CITY OF PORTLAND, MAINE

HISTORIC PRESERVATION BOARD

February 27, 2013

Re: Unapproved exterior lights and vacant sign bracket at 132 Spring Street

PROJECT: TOWNSEND REA
 132-134 SPRING STREET #
 TITLE: CHART: 39 BLOCK: D
 SIGN PERMIT APPLICA
 DRAWING NO: 005-1000

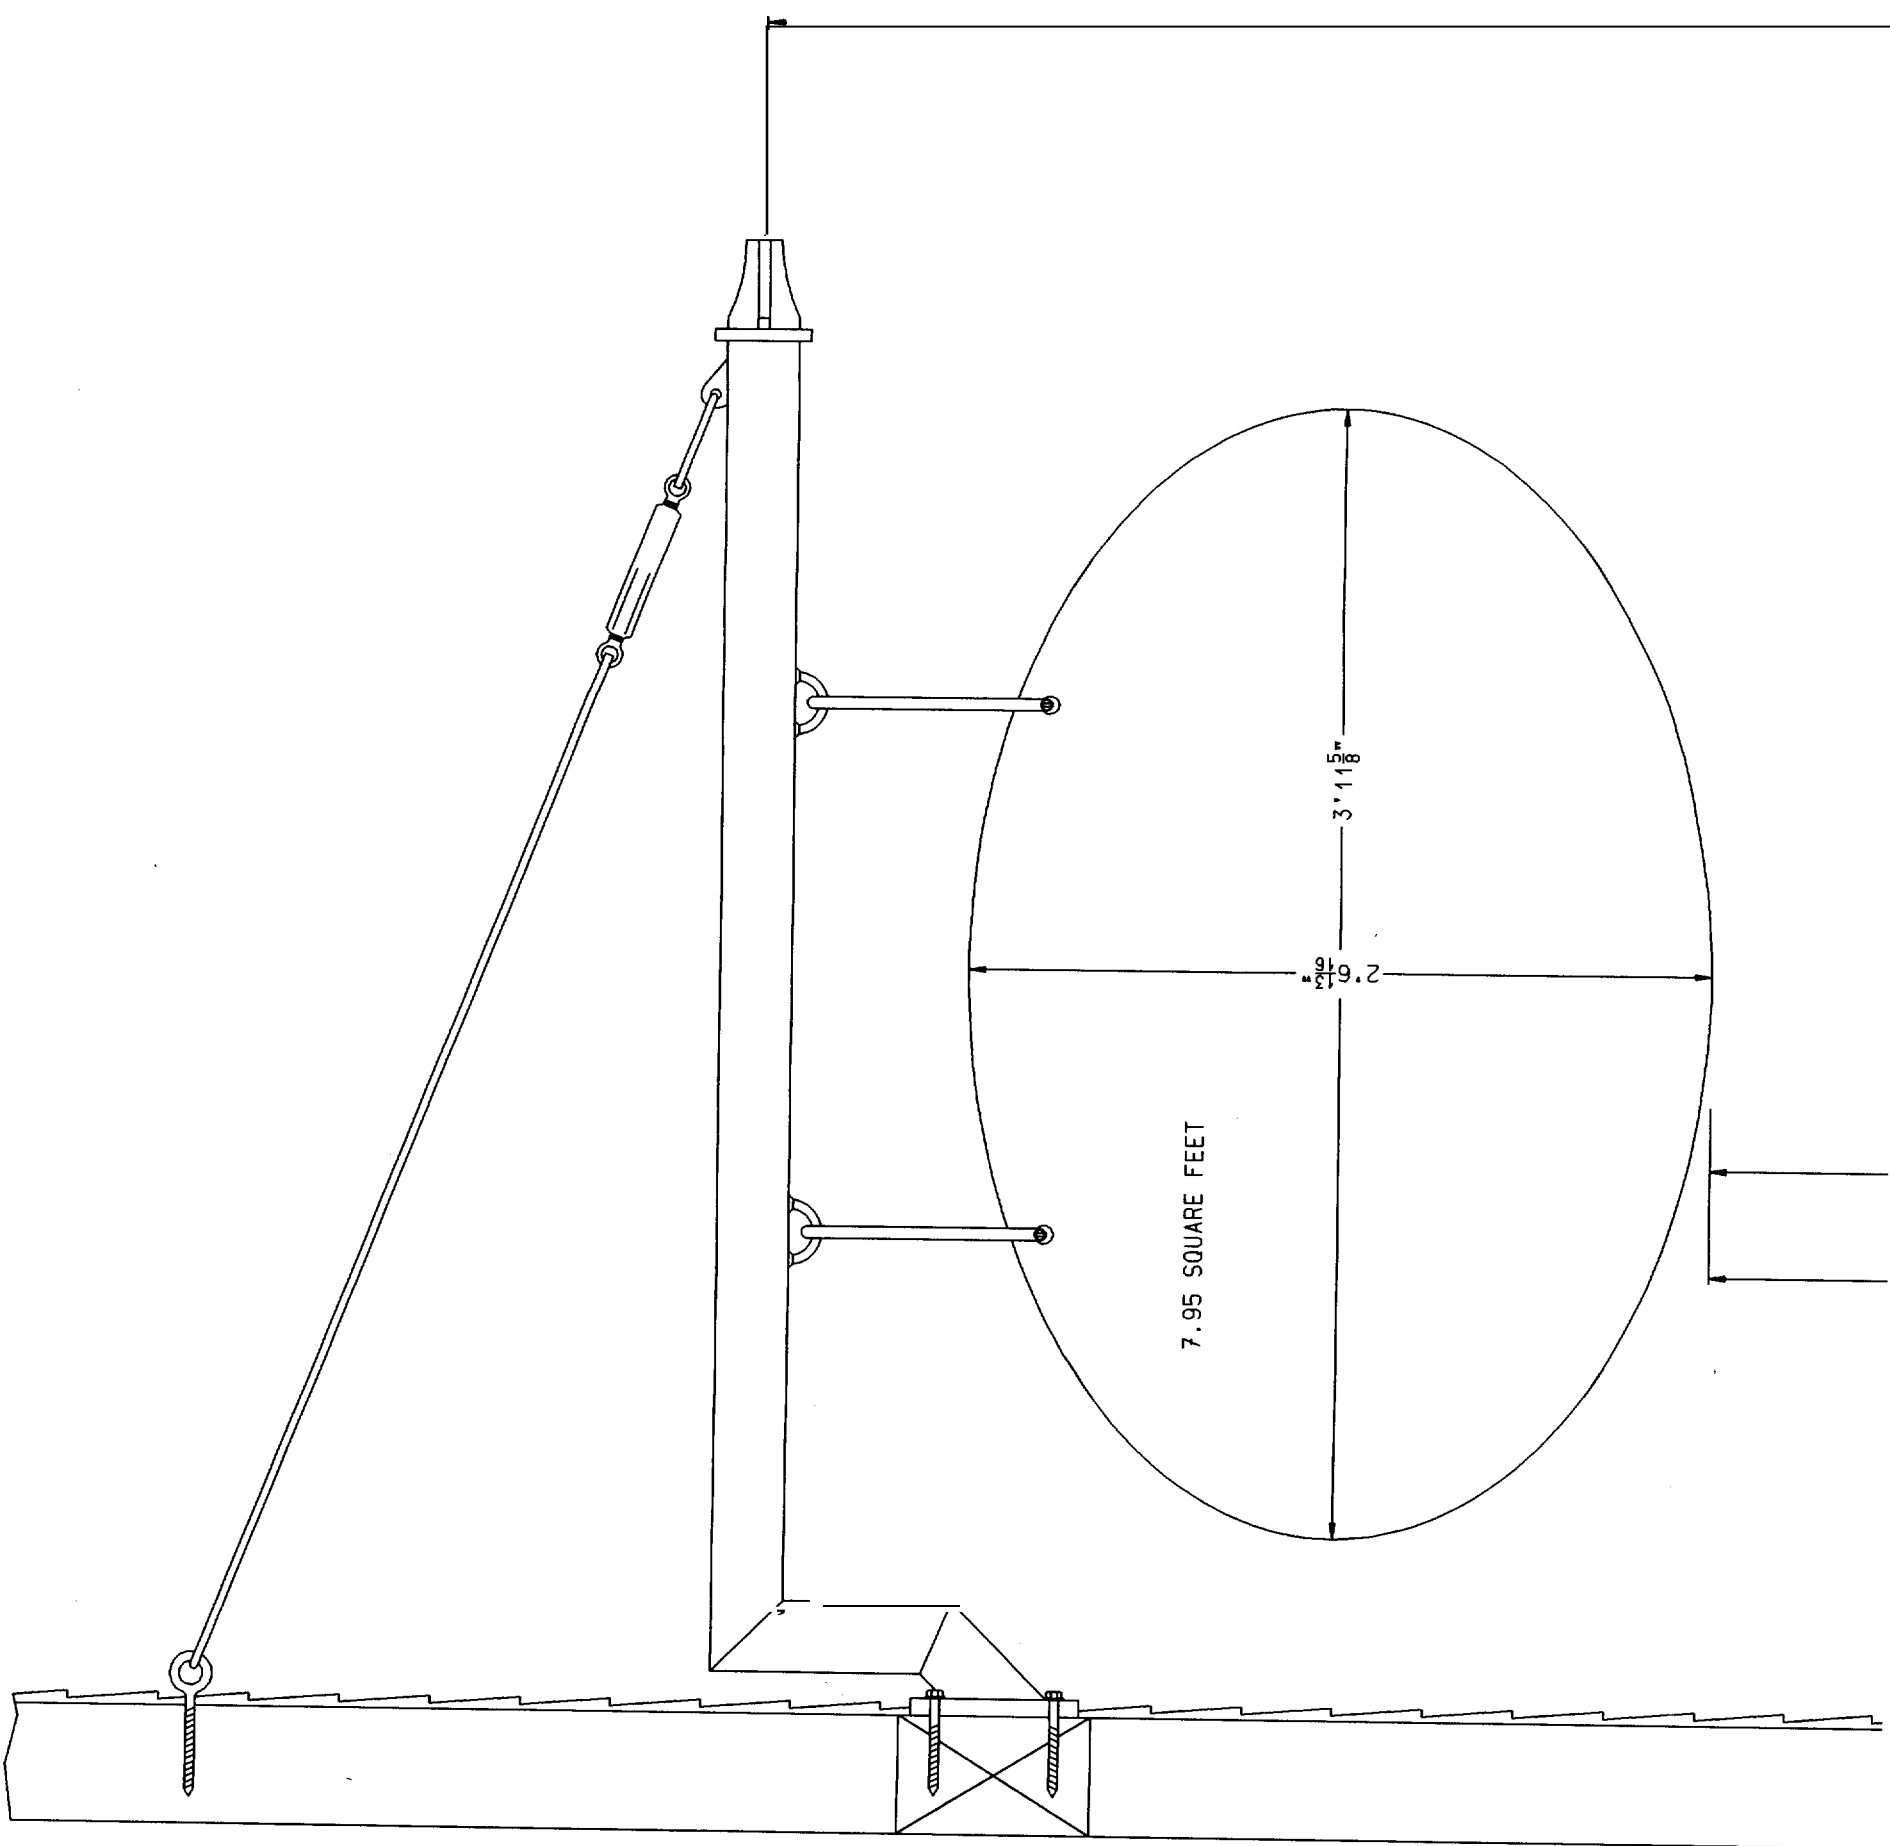
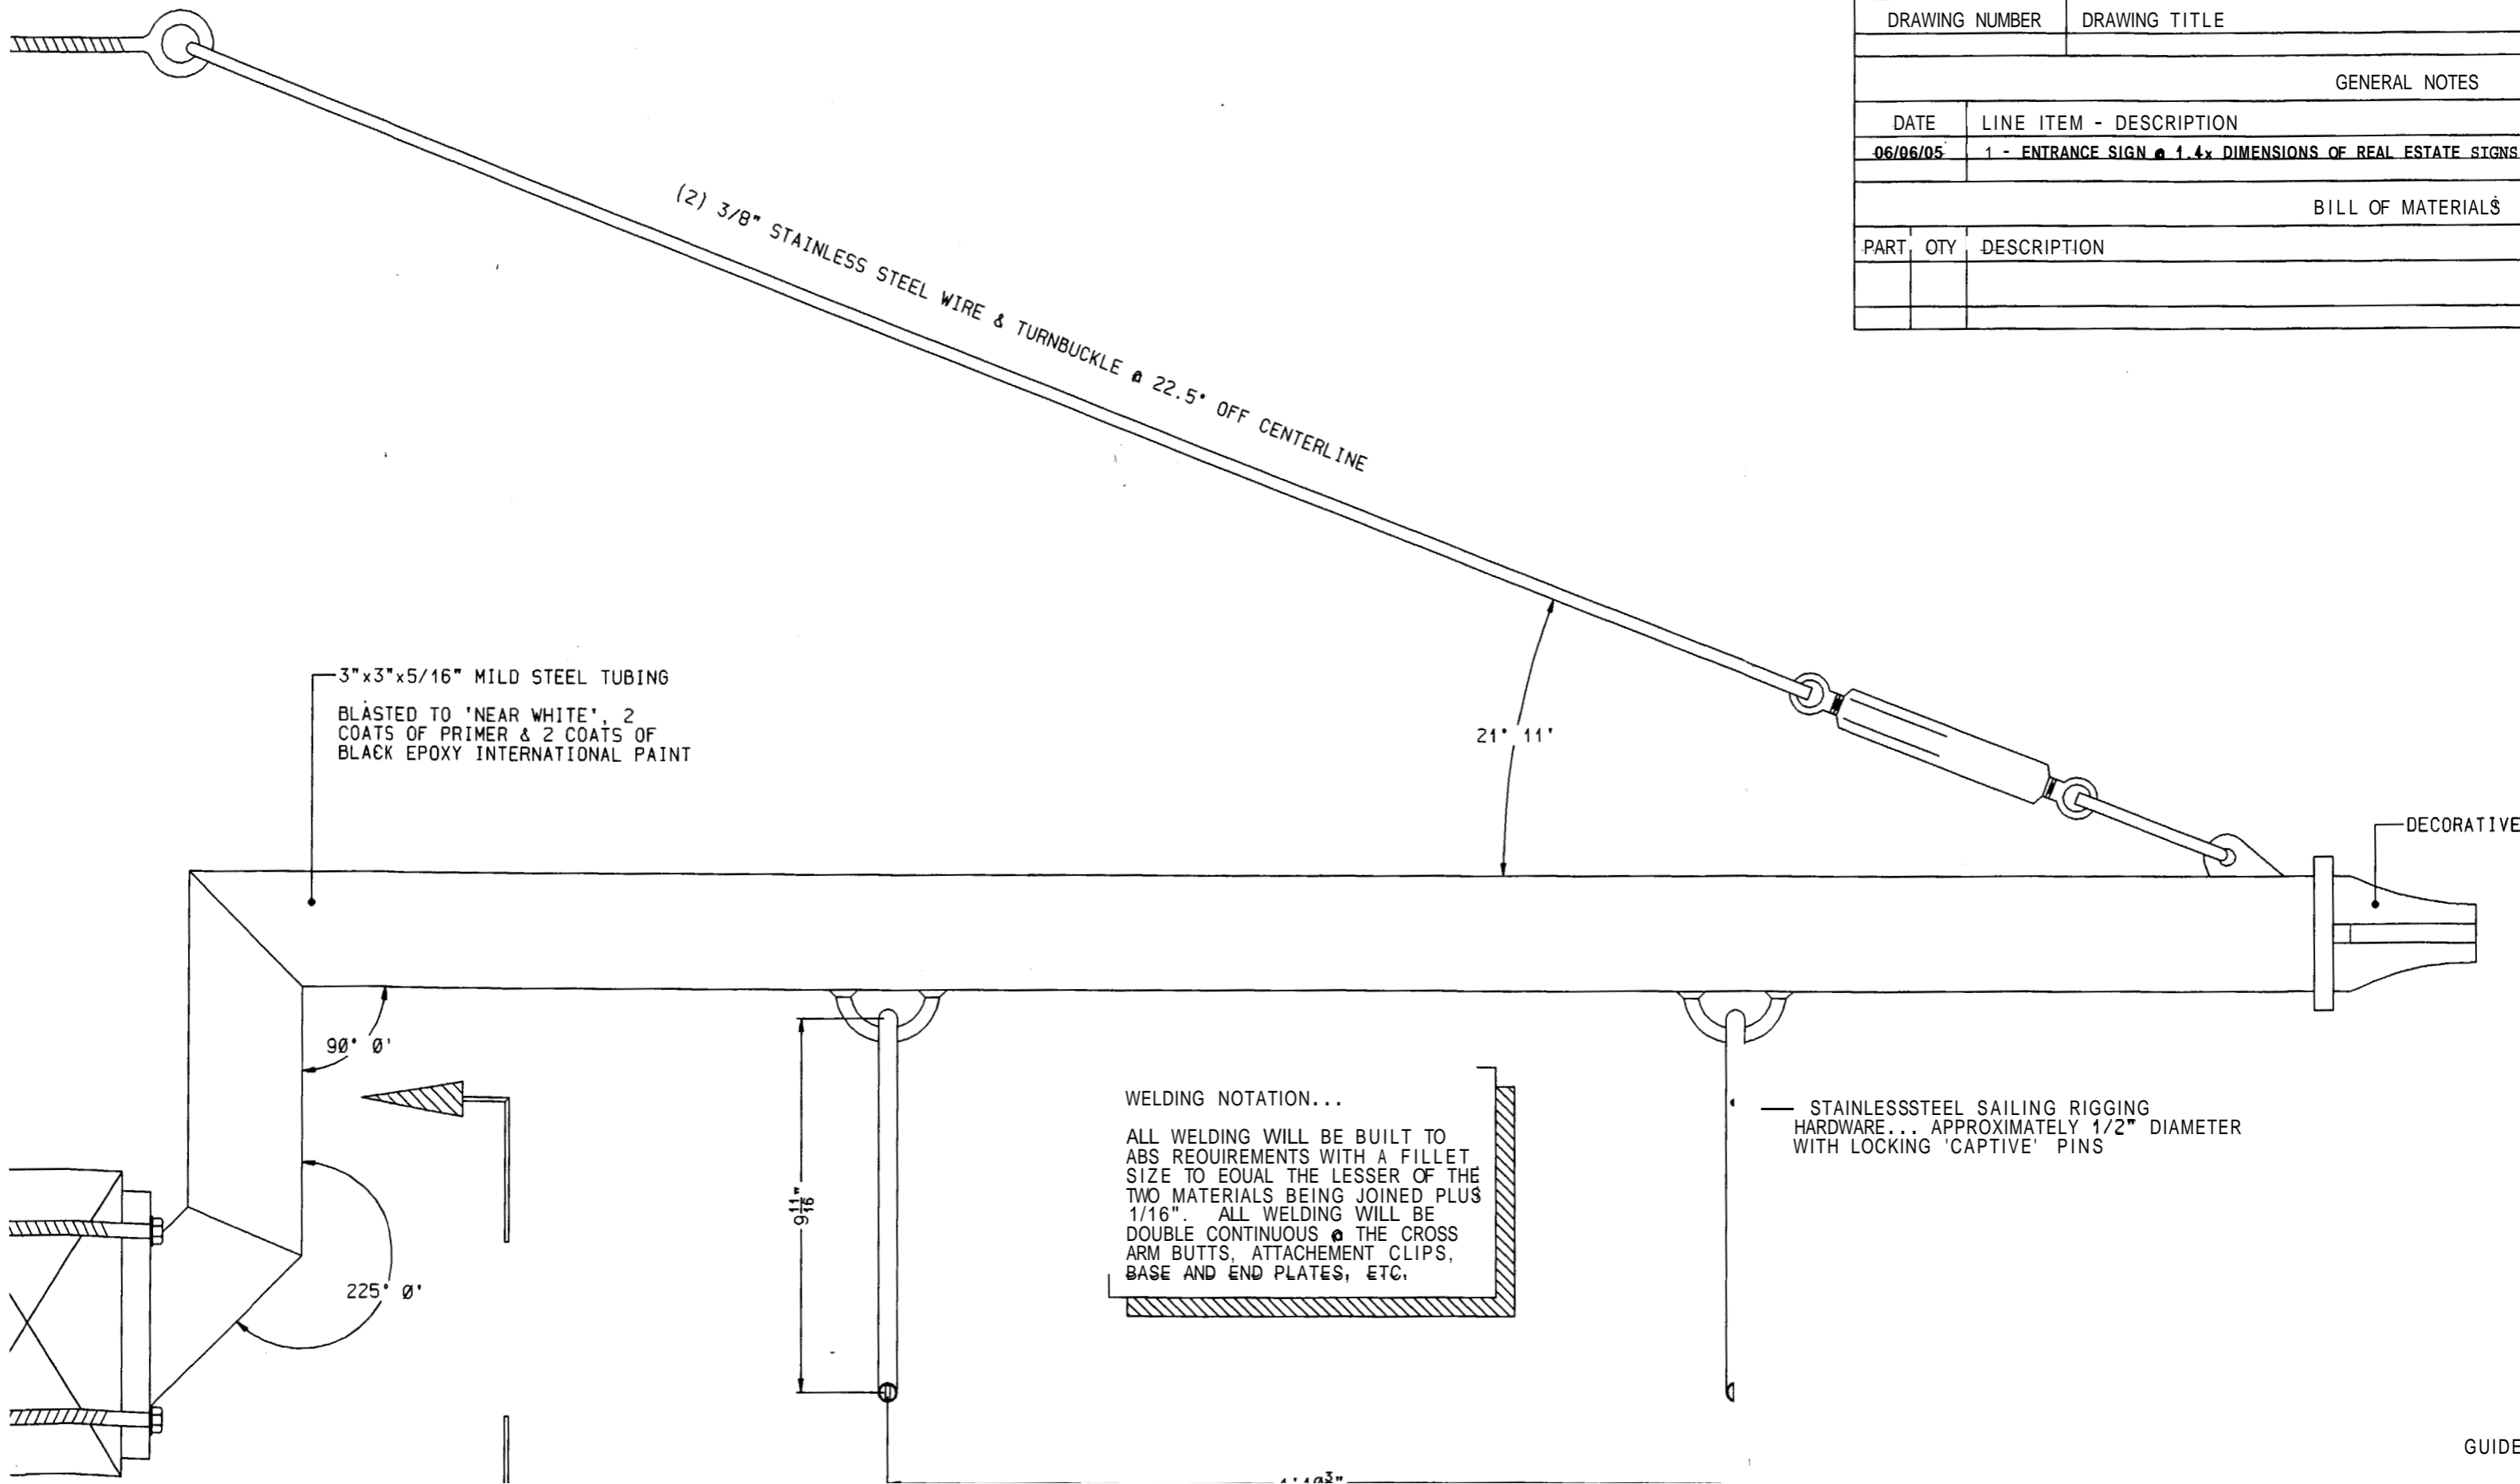
- 7/5/05: You applied for a sign permit, which was approved with conditions on 8/2/05. Historic Preservation Program Manager Deb Andrews noted: "***Approval is for sign and bracket only. Gooseneck lamps flanking proposed sign were installed without review or approval under historic preservation ordinance.***"

In the 2011 violation letter staff explained that the location of the gooseneck lamps bears no relation to the signage, and that gooseneck lights are typically used to illuminate a fascia sign positioned immediately below them. You have the right to file an application for an after-the-fact review of the lights, which would be reviewed by the Historic Preservation Board.

Otherwise, this office asks you to remove the gooseneck lights by May 1, 2013. We would be glad to work with you to find alternative lighting that could enhance the safety of your tenants and your property. I see there is a street light on the corner of Spring and Park, and it appears there are opportunities for lights to be installed at both entrances facing Spring Street.

We will look forward to reviewing an application for a new sign to hang on the existing bracket. Brackets that are unused for a long time should be removed, as they clutter a façade unnecessarily and suggest a long-term commercial stagnation.
